OUT21/1499

**Dubbo Quarry Continuation Project (SSD-10417) –
Environmental Impact Statement (EIS)**

Advice to DPIE Planning & Assessment regarding the Dubbo Quarry Continuation Project (SSD-10417) – EIS

Figure 1: Development layout (note for culvert design refer to condition B37)

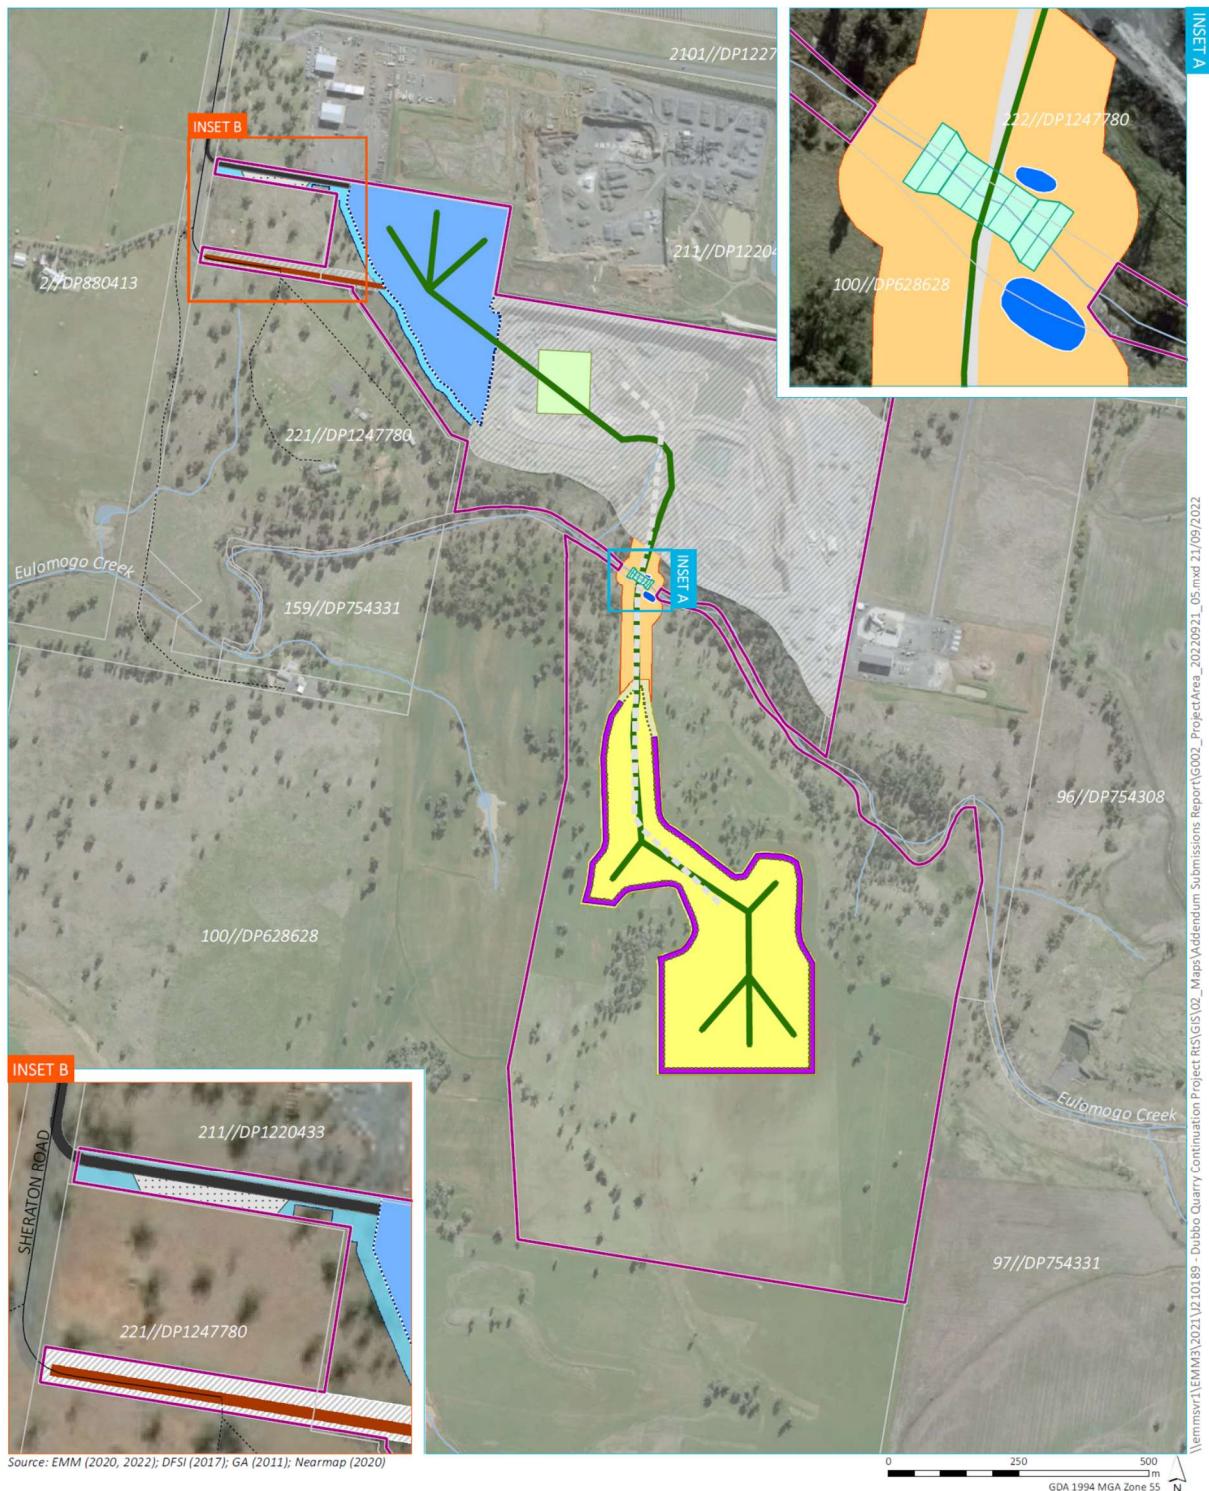
The proposed locations of sediment basins in close proximity to the creek banks near the Eulomogo Creek crossing are predicted to be inundated during a 20% Annual Exceedance Probability (AEP) and higher events. This is inconsistent with the Controlled Activity Approval (CAA) Guidelines which require such structures to be a minimum of 15m from a third order

Two culvert designs are proposed with both being 27m long and located within the creek channel. The key difference between the two designs is that one is pipe culverts, the other box culverts with the proponent preferring the pipe culverts option based on cost. In accordance with the Guidelines for Controlled Activities on Waterfront Land the box culvert option is preferred to pipes, and it is understood the modelled impacts are based on the box culvert option.

- c. Relocate the two sediment basins proposed near the Eulomogo Creek crossing to be a minimum 15m from the creeks high bank.
- d. Review alternate options for the proposed crossing, particularly the safety berm to reduce potential erosion and flooding impacts. In accordance with the CAA Guidelines the objective is to maintain the natural hydrologic regime which includes not increasing velocities, floodplain flows or water levels. Where impacts remain, adequate mitigating

measures need to be developed. Pipe culverts are not supported for the proposed creek crossing.

Figure 2: Water management system with surface water diversion

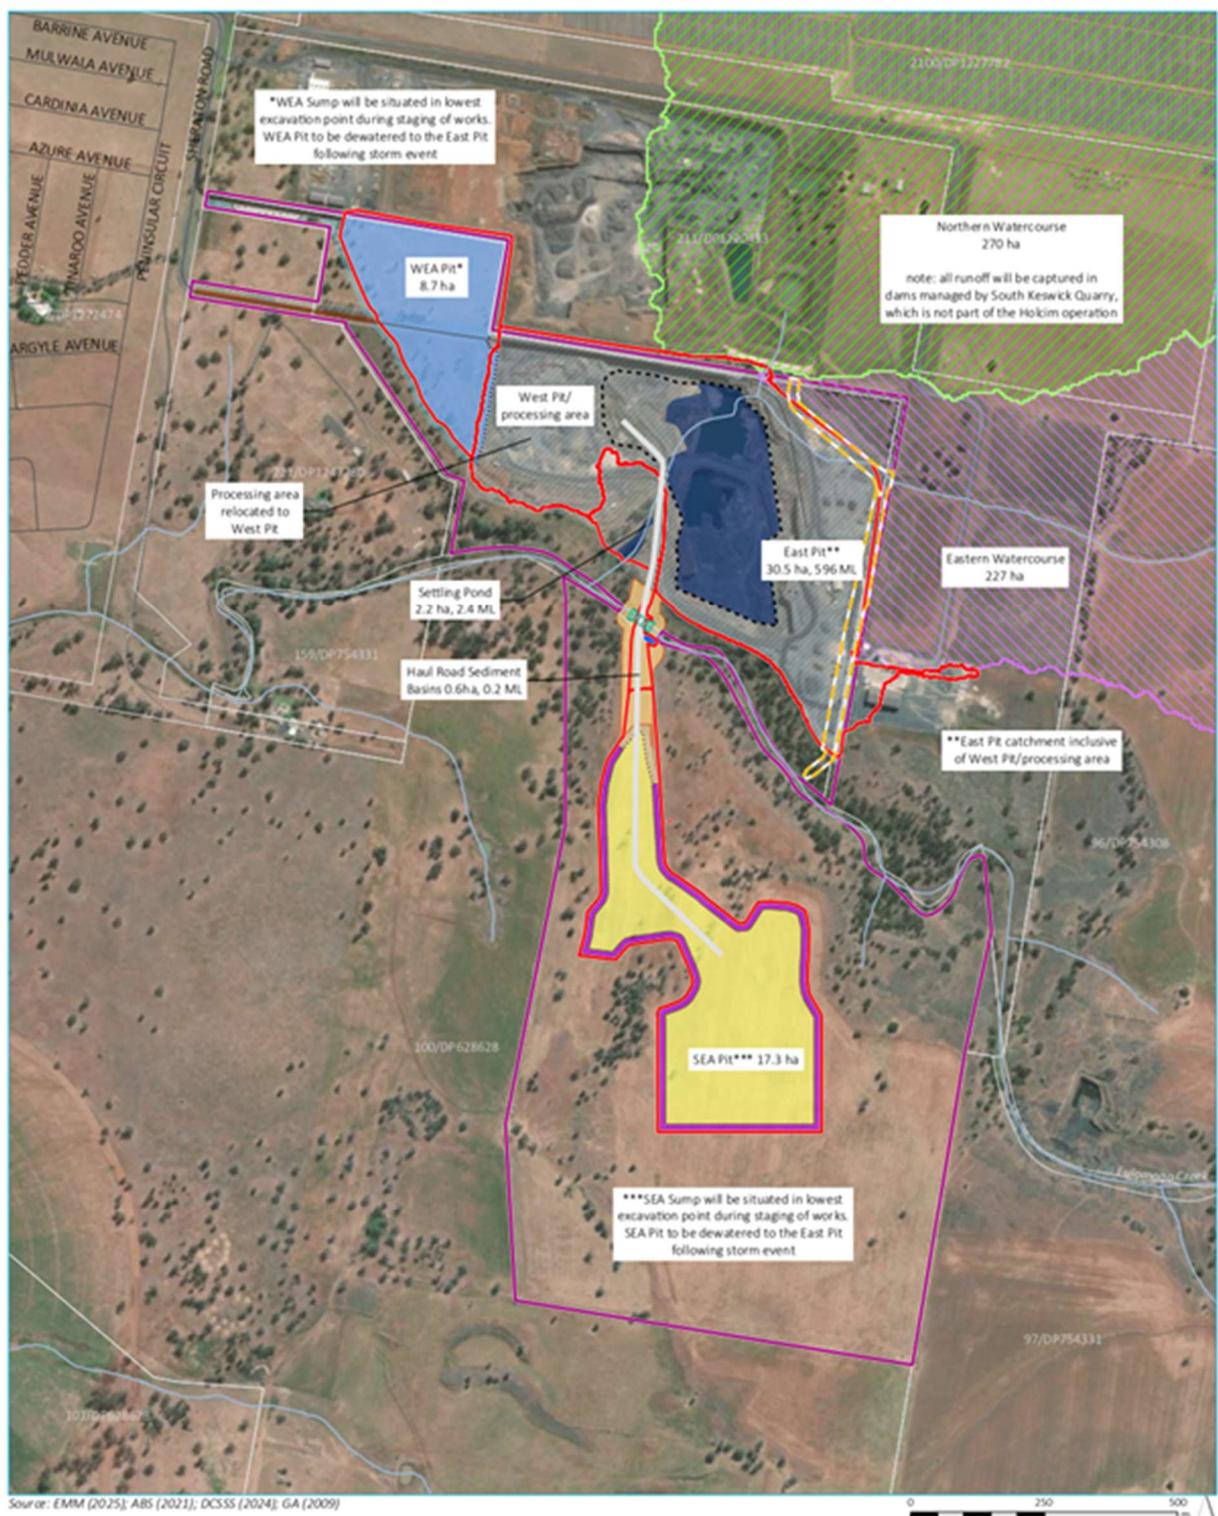
The existing and proposed water management strategy to enable clean runoff from the eastern watercourse to enter the east pit is inconsistent with the best practice requirement to separate clean and dirty water. It is recommended further consideration be given to install clean water diversions to maintain this clean runoff to the downstream environment. The water management system and associated water balance would then need to be reviewed due to an anticipated significant loss of water to the system.

- a. Review the ability to install clean water diversions to enable clean runoff from the eastern and northern watercourses to be maintained downstream. Where this can be achieved the water management system and water balance needs to be revised.

- b. Where clean runoff is to be captured in the east pit from the eastern and northern watercourses, the volume to be accounted for needs to be revised based on wet conditions. The ability to acquire the necessary entitlement needs to be demonstrated.
